### [BL-11-00005 Schnebly](#)

RE: Schnebly Boundary Line Adjustment, BL-11-00005

TO: Jeff Watson  
FROM: Christina Wollman, Planner II *CW*  
DATE: January 25, 2012  
SUBJECT: Schnebly BL-11-00005

Proposed 0.40 Acre Parcel

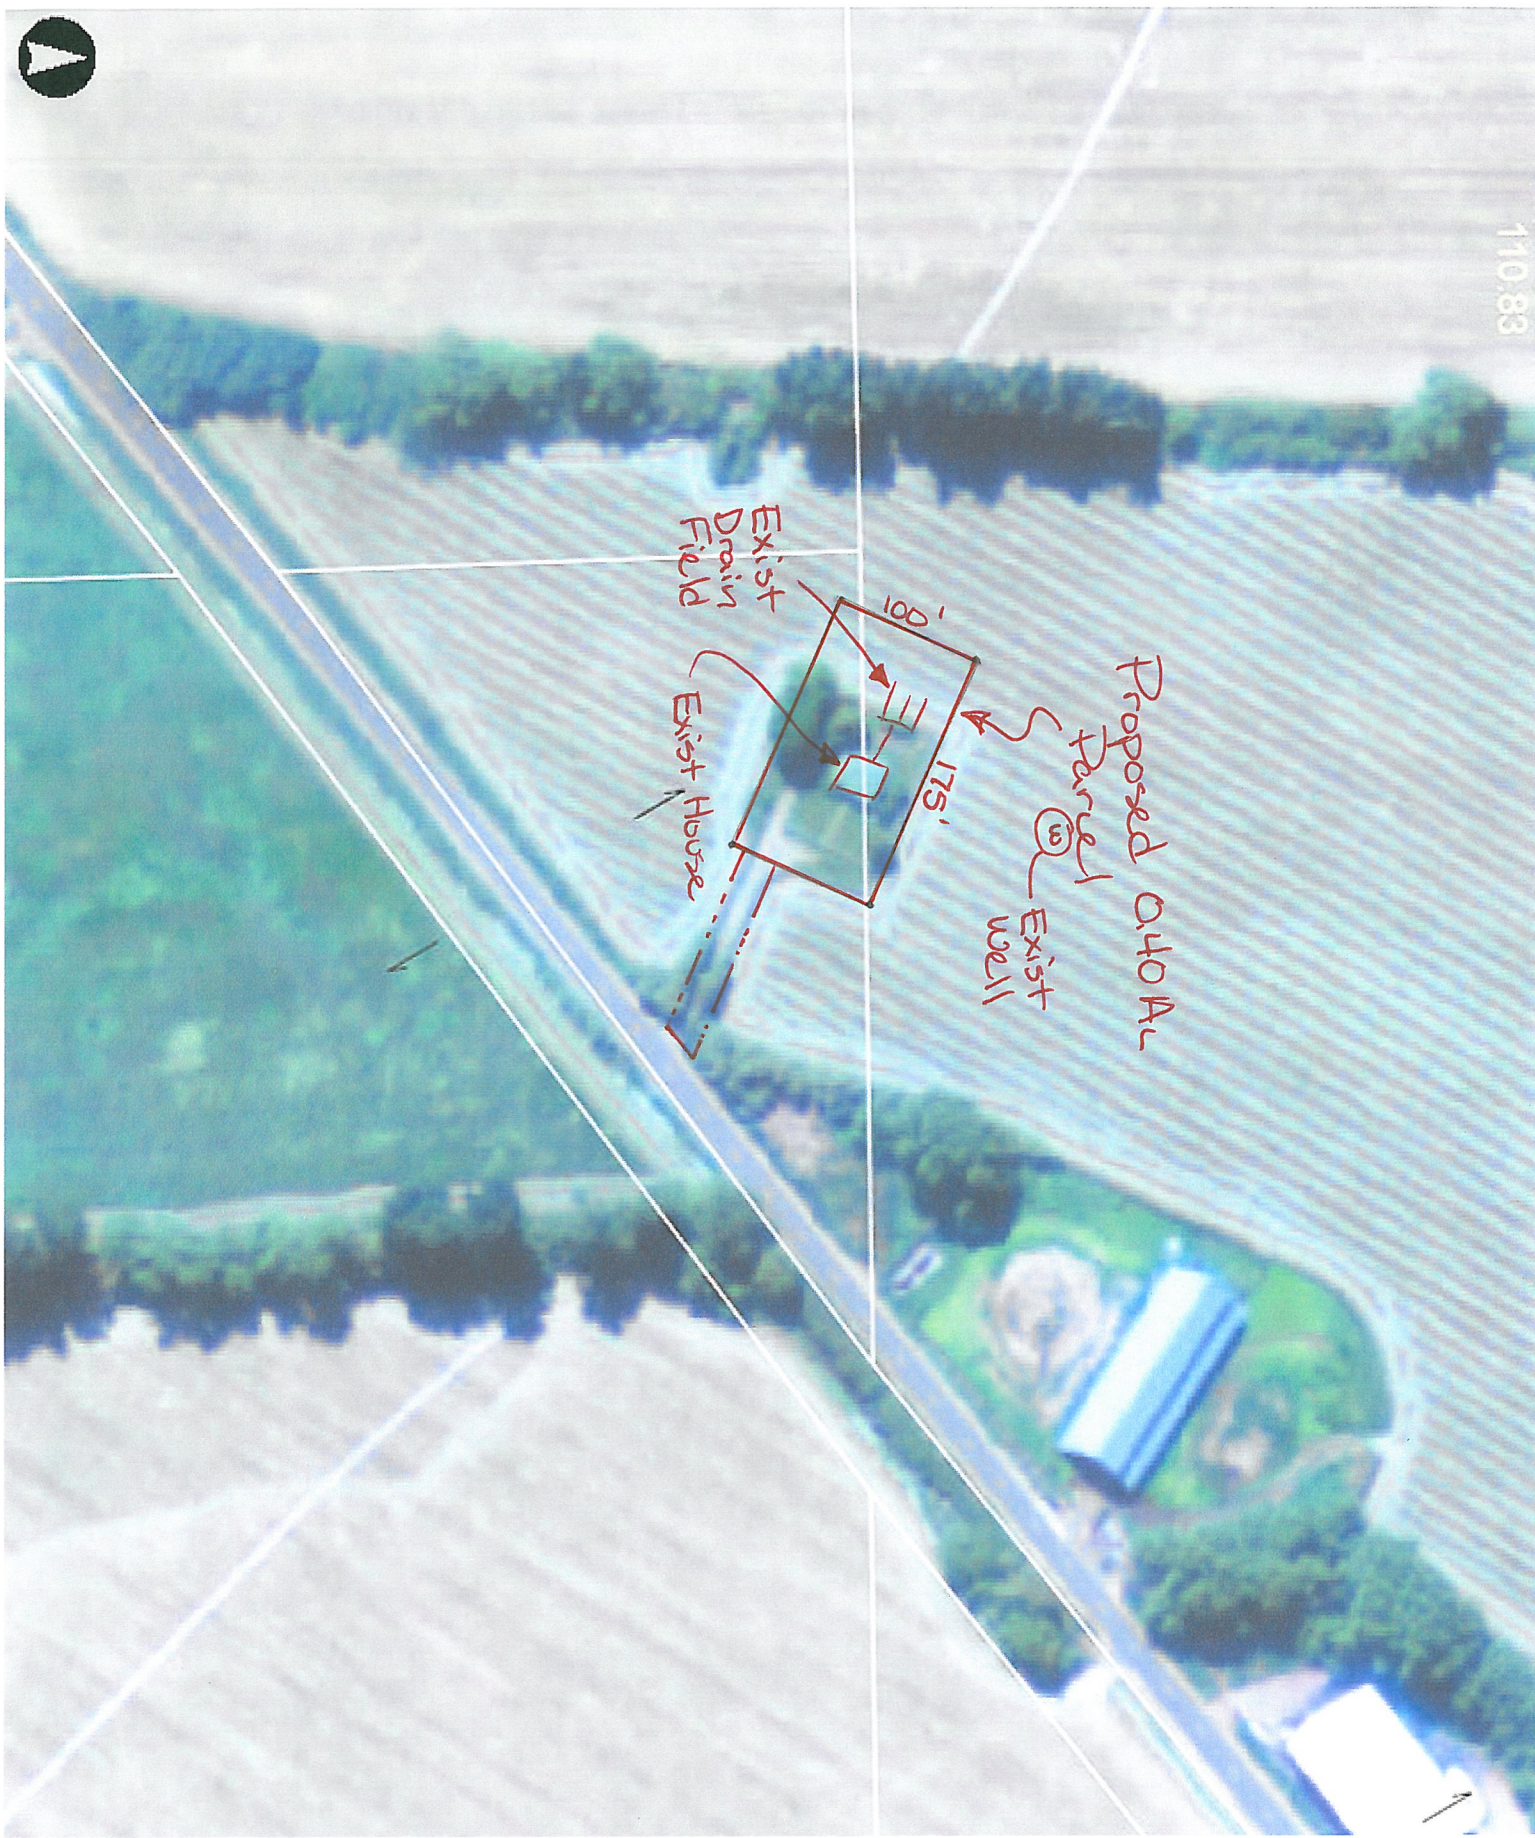
- Ensure that boundary line adjustments do not infringe upon existing structures, to include propane tanks, etc.
- Creation of any additional roads or access must comply with the International Fire Code.
- All future development must comply with the International Fire Code.

1. The proposed access with appropriate easement(s) shall be shown and shall conform to applicable Kittitas County Road Standards.
2. A revised legal description that describes the final configuration of the subject property shall be required.

It appears that the well is over 50 feet from the property line in this one and that the on-site sewage system is within the proposed 0.40 acres. I see no issues with this one.
